KIRKLEES METROPOLITAN COUNCIL INVESTMENT & REGENERATION SERVICE

Town and Country Planning Act 1990 (as amended) – SECTION 73

Reference No:	2026/70/90808/W
Site Address:	Cellars Clough House, Manchester Road, Marsden, Huddersfield, HD7 6LY
Description:	Variation of conditions 2 (plans) , 3 (materials), 4 (roof use only) and 5 (land stability works) on previous permission 2023/92557 for erection of single storey side extension with terrace above and associated alterations
Recommending Officer:	Danielle Cooper

Officer Report

rev	date	description			
Project <b>CELLAR CLOUGH HOUSE, MARSDEN</b>					
Title <b>ELEVATIONS AS PROPOSED</b>					
Project No	23-07	Drawing No	L(-4)021	Status	PLANNING
Scale	1:100@A3	Date	JULY 2023	Rev	01

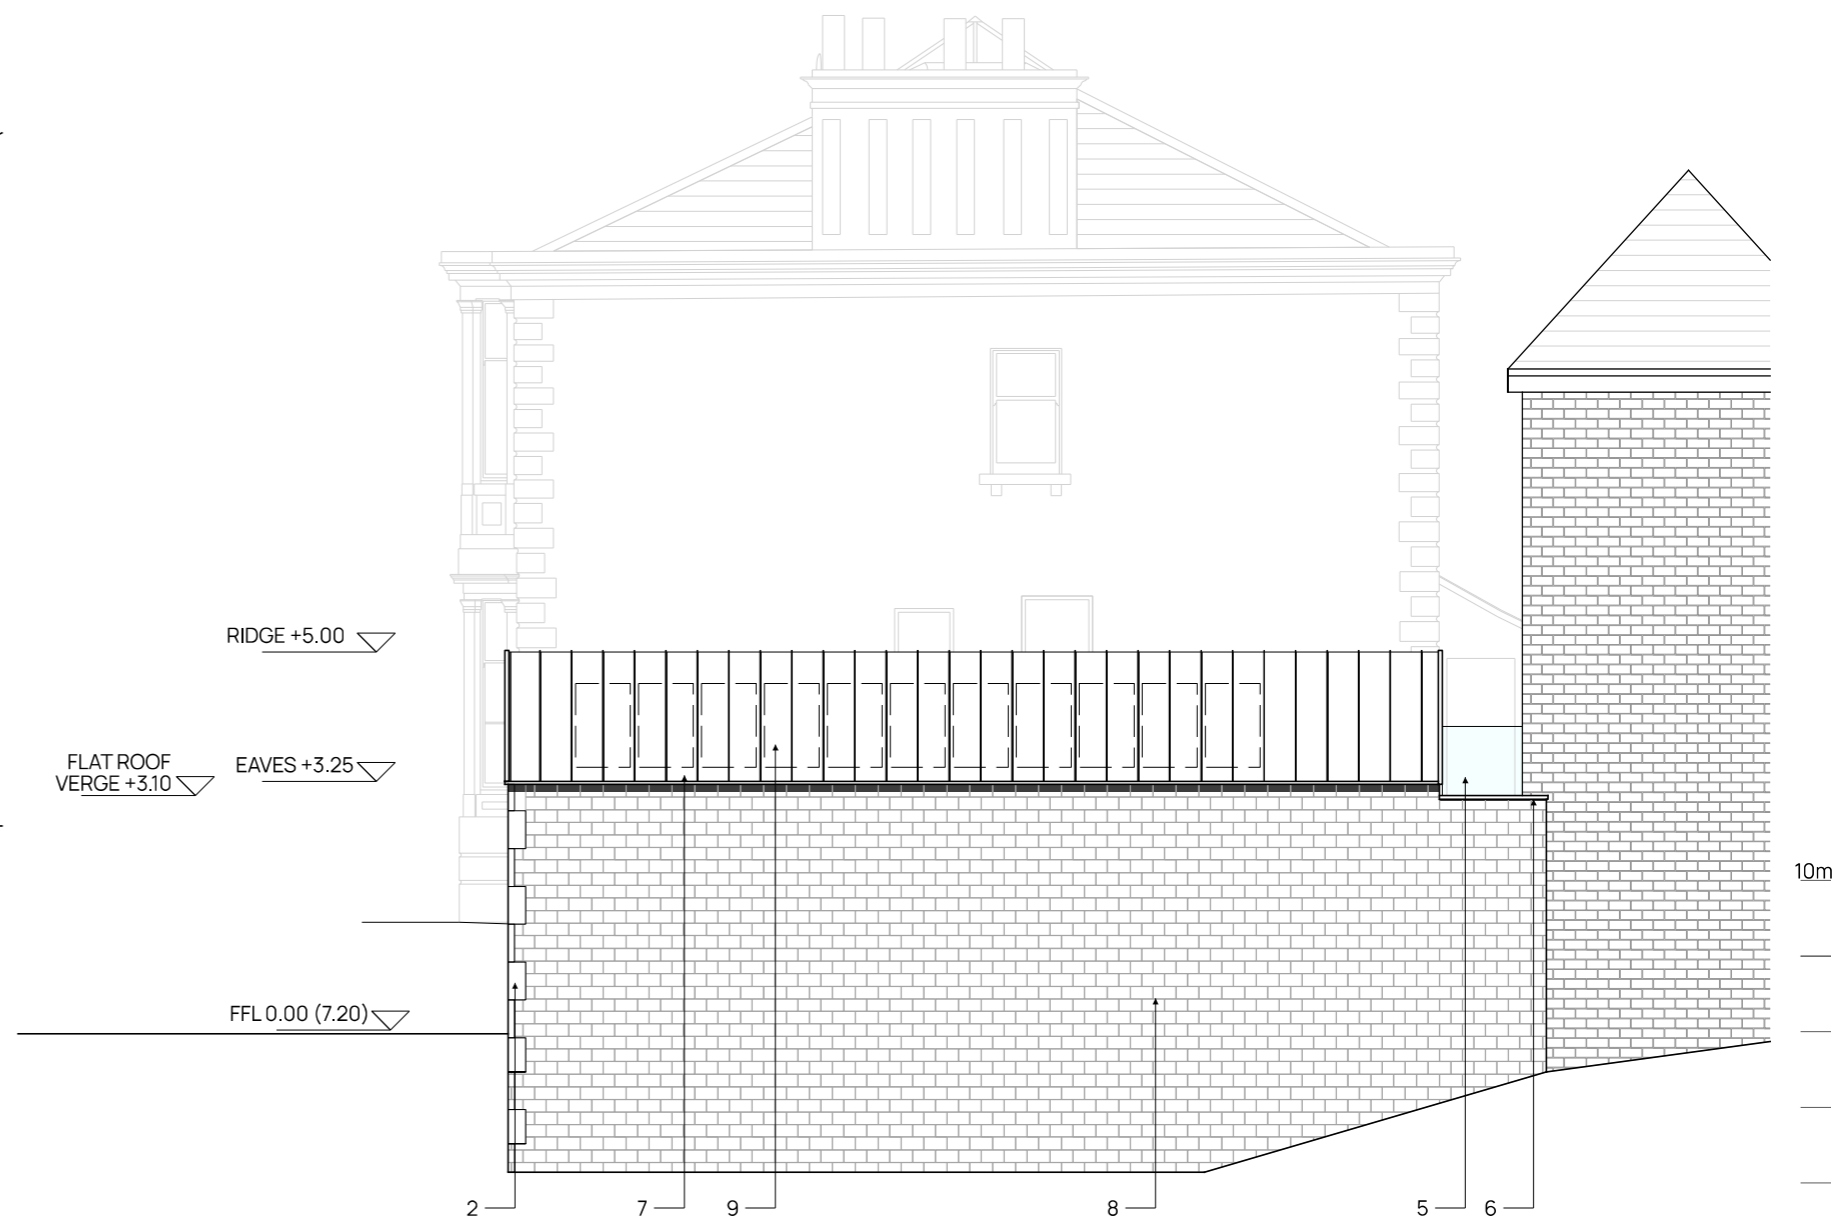
Due to technical requirements, the height of the approved extension is proposed to be increased by 350mm. It is also proposed to increase the roof length of the approved extension by 1.8m to allow further height of the pool area.

It is also proposed to have metal coping along the proposed lining of the proposed flat roof element of the proposal to match the zinc roof as approved. The side and rear elevation of the pitched roof extension will also be constructed from rough coursed stone and a sample has been shown on the submitted revised elevation plans.

Due to technical requirements, the height of the approved extension is proposed to be increased by 350mm. It is also proposed to increase the

In addition, it is also proposed to have metal coping along the proposed lining of the proposed flat roof element of the proposal to match the zinc roof as approved. The side and rear elevation of the pitched roof extension will also be constructed from rough coursed stone and a sample has been provided on the submitted revised elevation plans. The Local Planning Authority (LPA) consider the change in materials as explained will respect the character and materials of the host building and are therefore acceptable ensuring the visual amenity of the proposed extension and host building are protected.

The materials of construction of the development hereby shall be in accordance with those set out within submitted plans L(-4)021 rev 01, L(-4)011 rev 01, L(-4)031 rev 01 and thereafter retained.

3)The materials of construction of the development hereby shall be in accordance with those set out within submitted plans L(-4)021 rev 01, L(-4)011 rev 01, L(-4)031 rev 01 and thereafter retained.

Drawing No GSL3324_GDR_DWG001	Revision A
----------------------------------	---------------

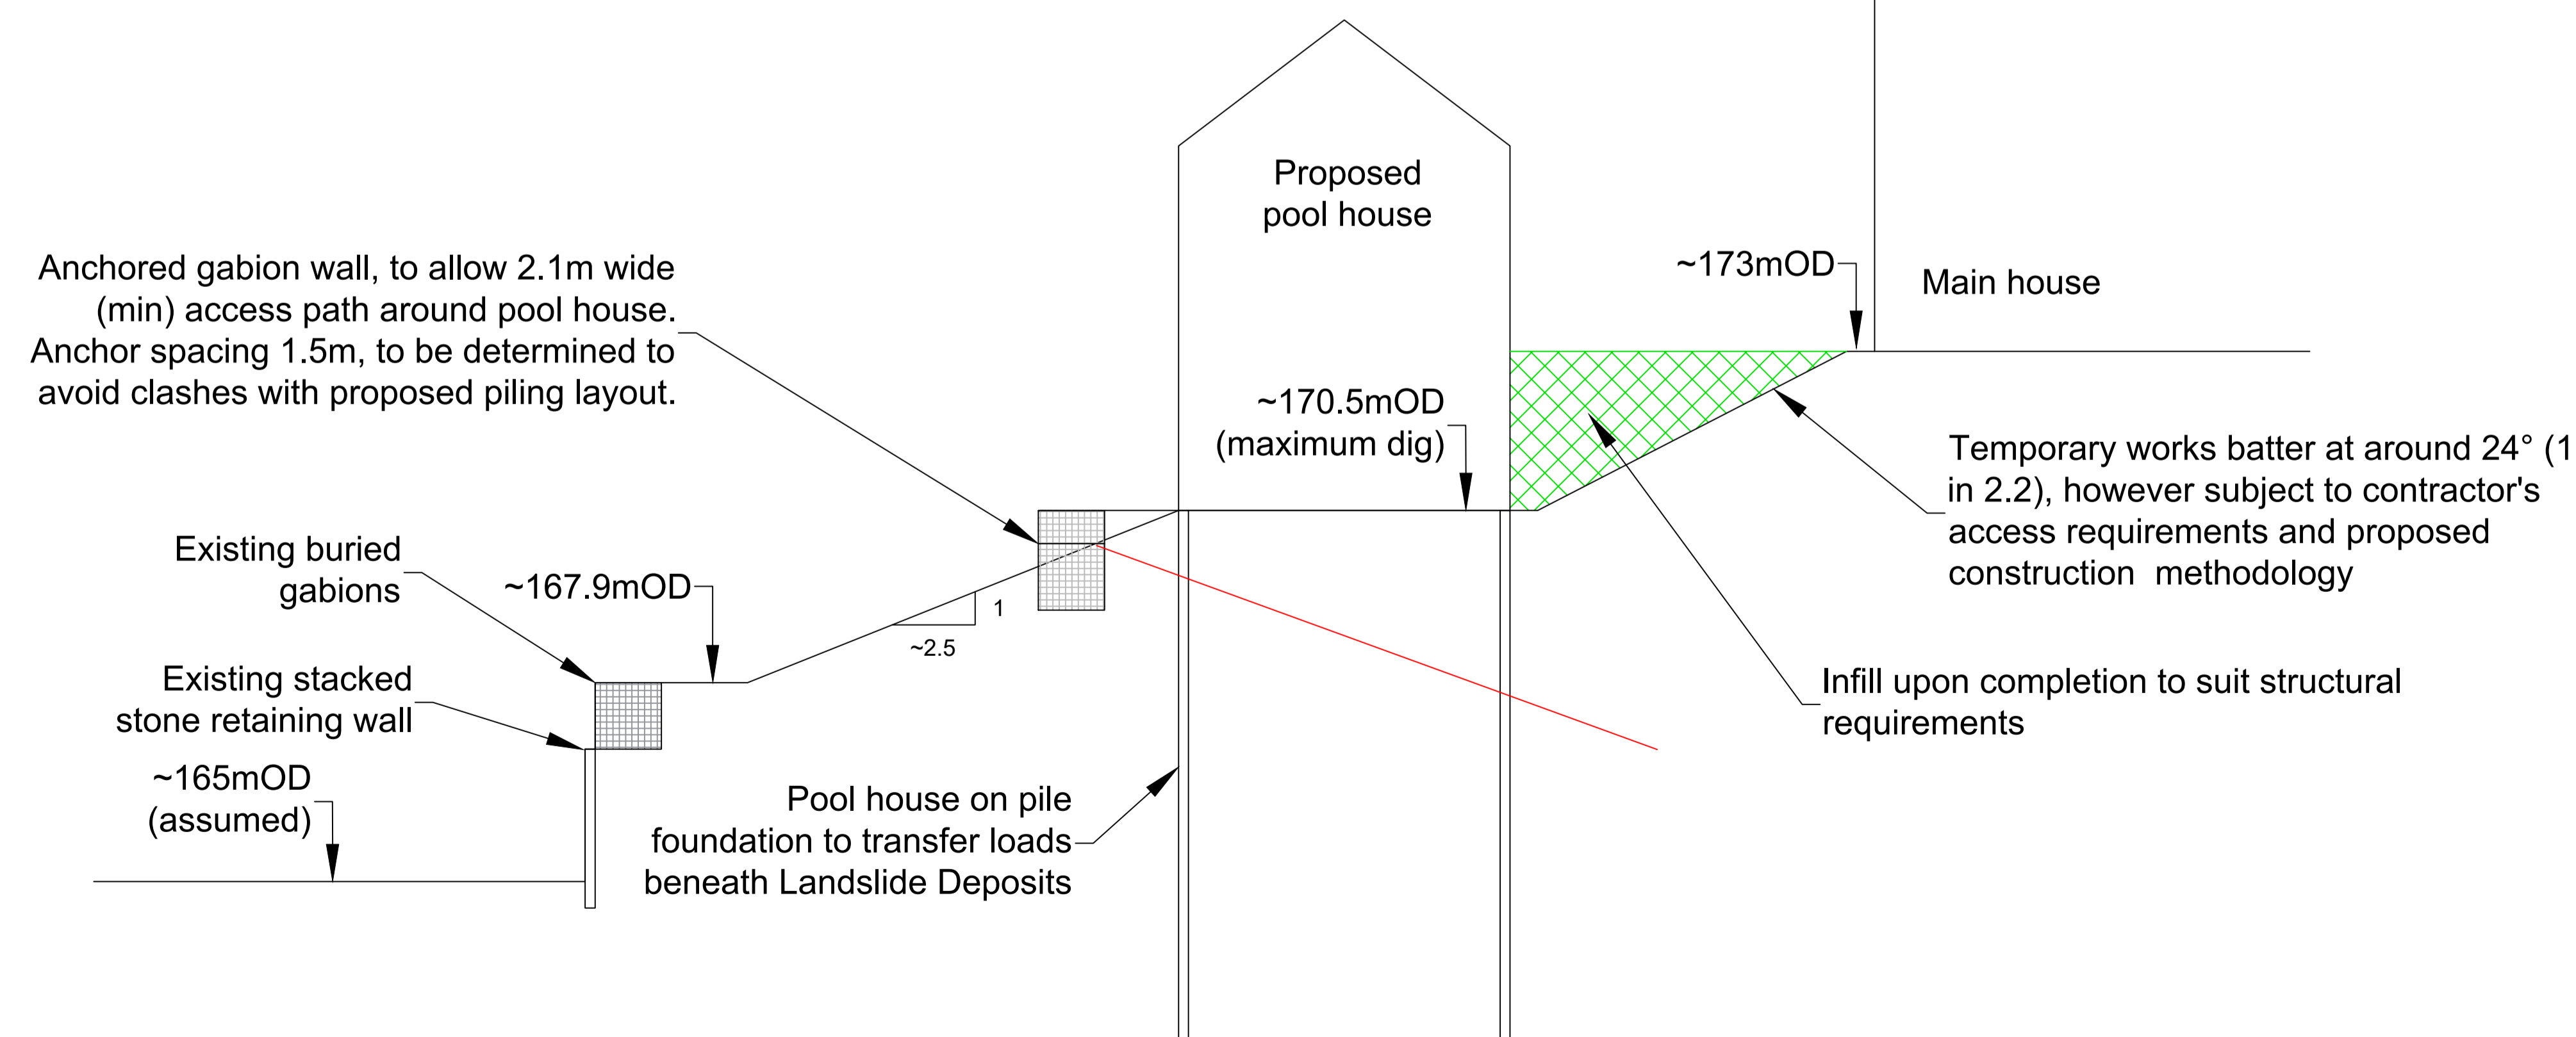
Condition 5 requires that all works relating to land stability be carried out in accordance with the details originally submitted. Since the application was approved, however, a new geotechnical consultant has been appointed who has proposed an alternative slope-stabilisation design to that previously approved. It is therefore requested that the drawing and document references cited in the condition be amended to refer to the new documents submitted by the Geotechnical Consultant, which reflect the updated design.

Condition 5 of the original permission requires that all works relating to land stability be carried out in accordance with the details originally submitted. Since the application was approved, however, a new geotechnical consultant has been appointed who has proposed an alternative slope-stabilisation design to that previously approved. It is therefore requested that the drawing and document references cited in the condition be amended to refer to the new documents submitted by the Geotechnical Consultant, which reflect the updated design.

GSL3324_GDR_DWG002 rev A and GSL3324_GDR_DWG001 rev A, and the details as contained within the Geotechnical design report, by GroundSolve Ltd (ref: GSL_3324_GDR_001_Rev3) which shall be retained thereafter.

GSL3324_GDR_DWG002 rev A and GSL3324_GDR_DWG001 rev A, and the details as contained within the Geotechnical design report, by GroundSolve Ltd (ref: GSL_3324_GDR_001_Rev3) which shall be retained thereafter.
